August 20, 2019
El Paso County Development Services
Attn: Lindsay Darden
2880 International Circle, Ste 110
Colorado Springs, CO 80910

**SUBJECT: The Sod Guy
 Sales Lot
 Drainage Letter – Lot 1 in Appaloosa Highway 24 Subdivision Filing No 1A**

### LOT 1, APPALOOSA HIGHWAY 24 SUBDIVISION FILING NO 1A

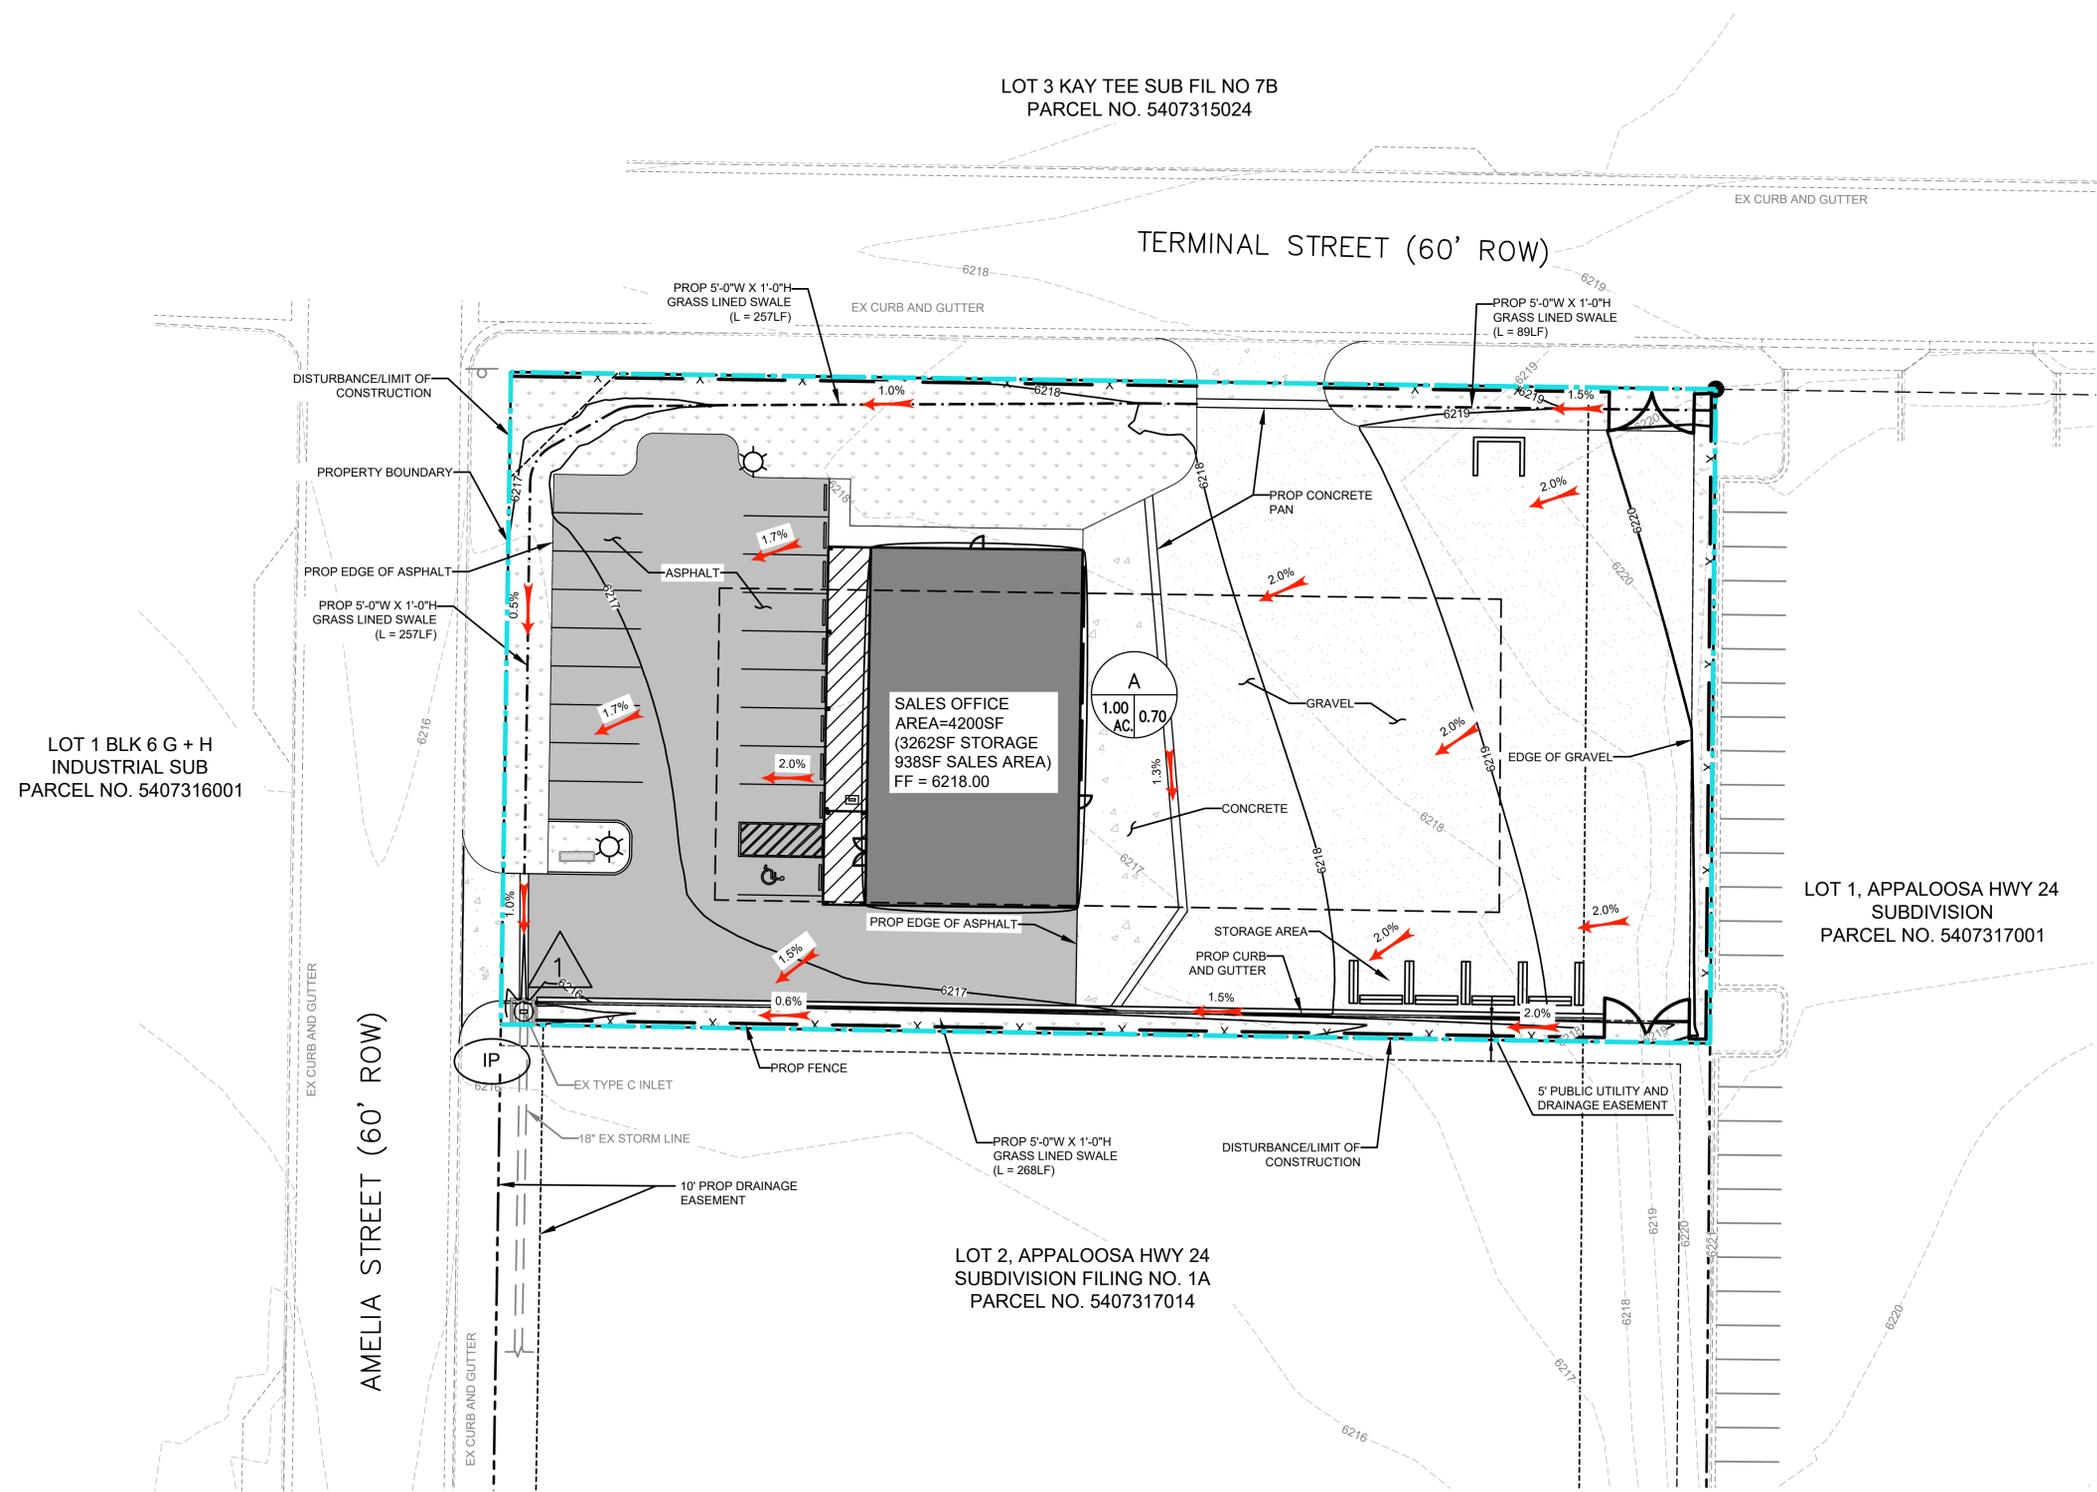
Provide existing and proposed drainage map for Lot 1.
 Provide computation of the Lot 1 percent impervious, c-values and Q5/Q100 to show it's in conformance with the approved Appaloosa Hwy 24 subdivision FDR.
 Provide a vicinity map

However, a developed drainage map must still be provided of the lot showing the proposed layout with sub-basin boundary, flow direction, and contours.
